Lead Local Flood Authority

RE: LU/72/25/OUT - Paynters Croft, Burndell Road, Arundel, BN18 0HR

We **object** to this planning application in the absence of an acceptable Flood Risk Assessment (FRA) and Drainage Strategy relating to:

-EXISTING SITE KEY-	
	Site Boundary (17706 m ² - 1.8 Ha.)
	Existing Spot Level
	Existing Contour (Primary)
	Existing Contour (Secondary)
	Overland Flow Arrow
	Site Low Point

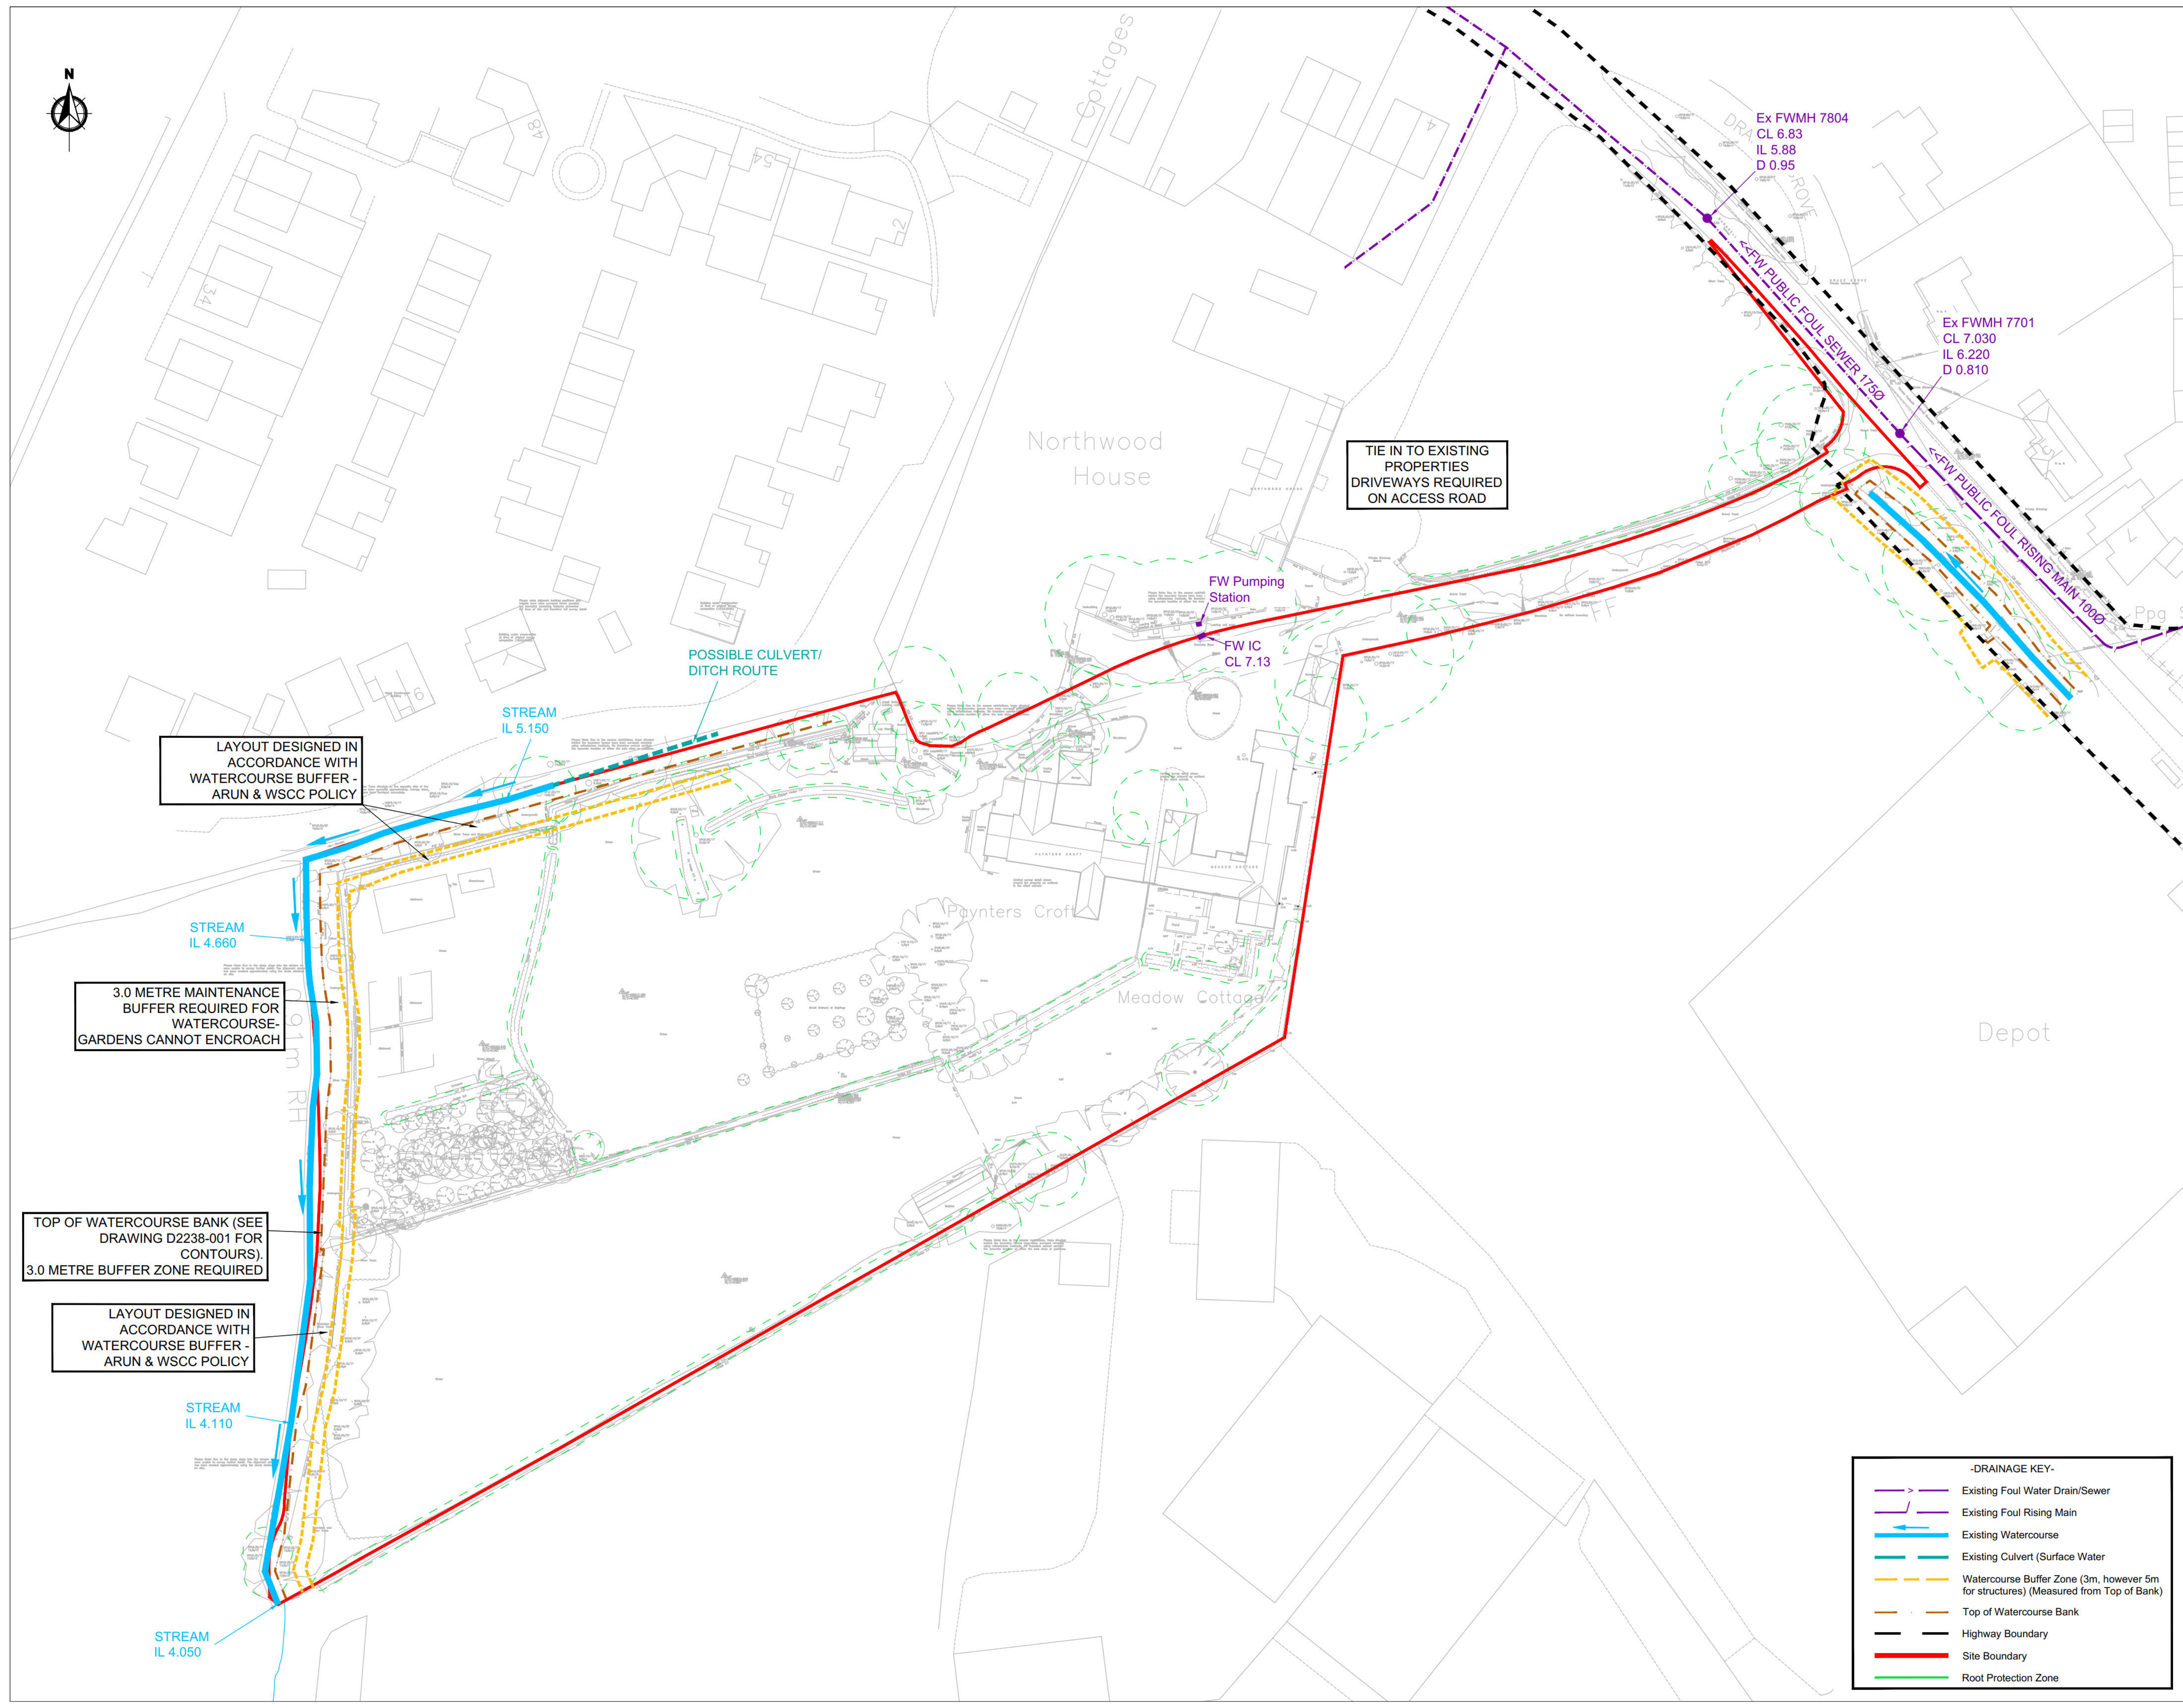
1. While we appreciate that this is an Outline application, we are concerned over the existing surface water flood risk at the site. We note the explanation that the flooding is the result of low points at the site, but we feel that further evidence is needed to ensure that this can be managed by an appropriate mitigation scheme or drainage strategy on the site.

8. Further clarification with respect to exceedance. Many references to "follow the site's natural topography" however updated plans/further evidence in form of exceedance drawings, depths, pathways to demonstrate that homes remain dry.

-GEOTECHNICAL KEY-
Groundwater Monitoring Point

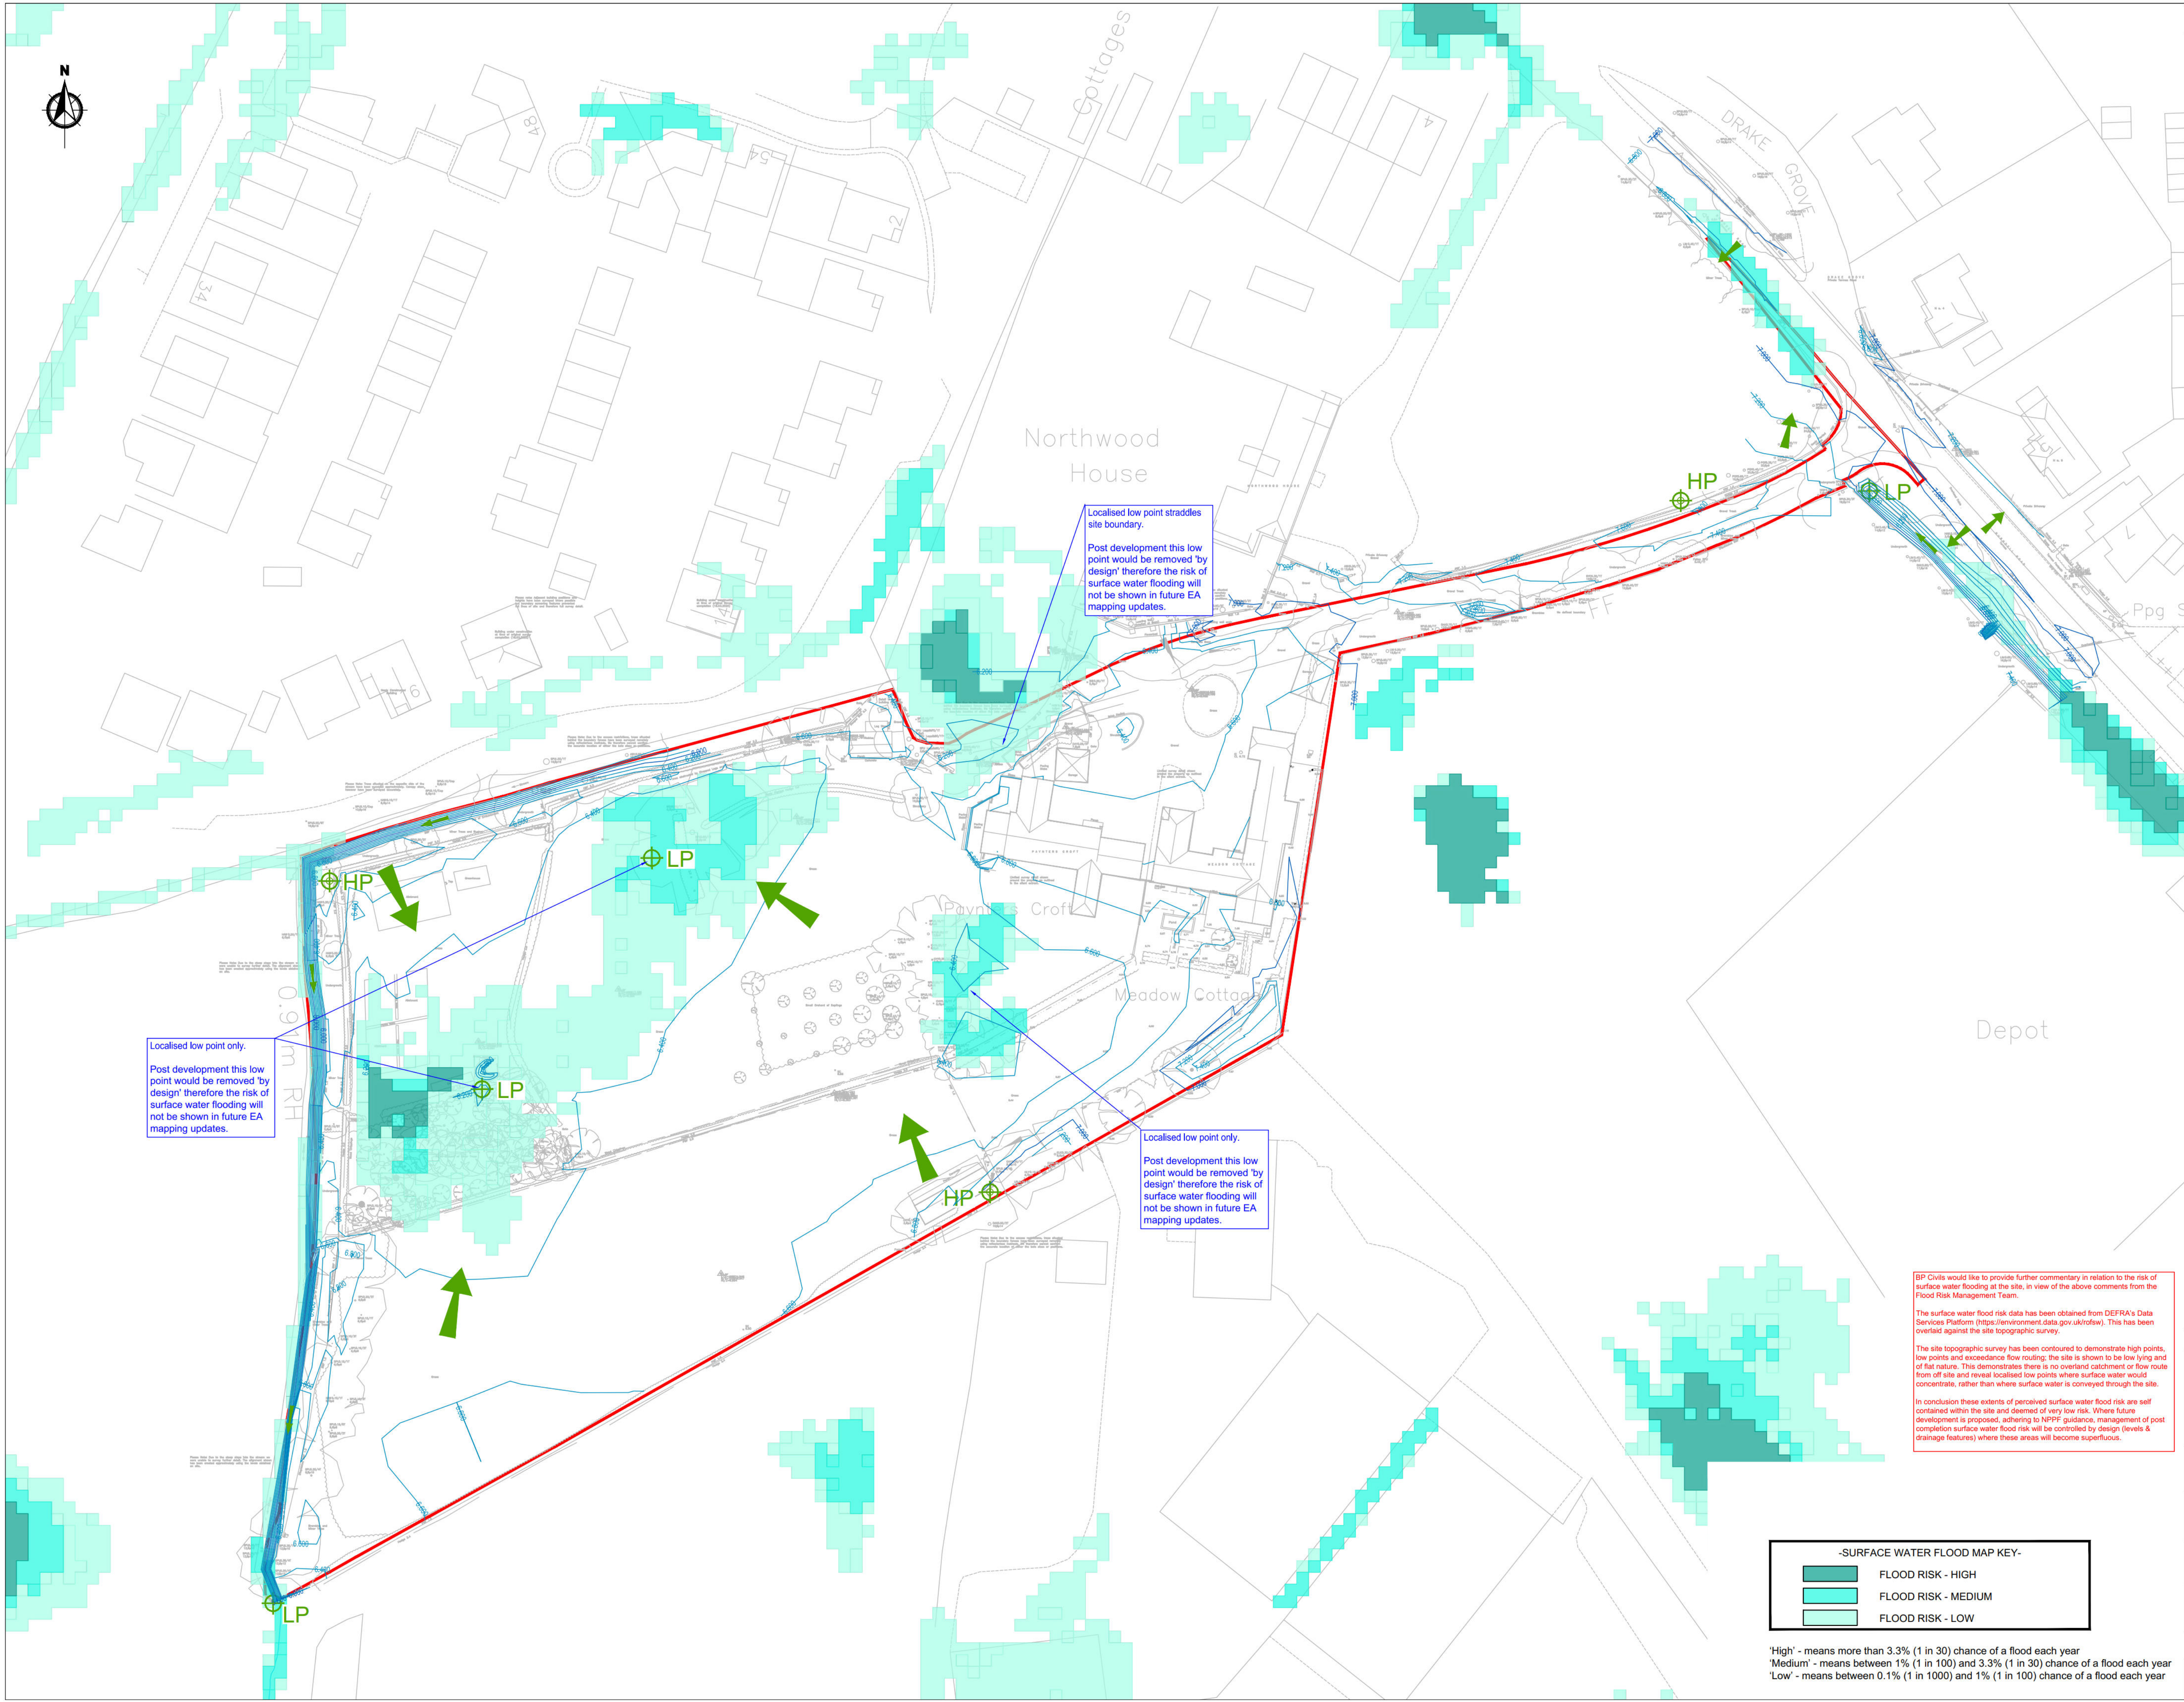
5. Further percolation testing and groundwater monitoring required at site of any SuDs features.
6. Ensure 1m freeboard of any solution above groundwater level. Base of any proposed structures must be above this.

7. The applicant has demonstrated infiltration potential through BRE365 testing. However, groundwater has been recorded at shallow depths. Please provide confirmation of the minimum separation between anticipated winter groundwater levels and the proposed infiltration system and demonstrate why infiltration drainage is not feasible in accordance with the drainage hierarchy.
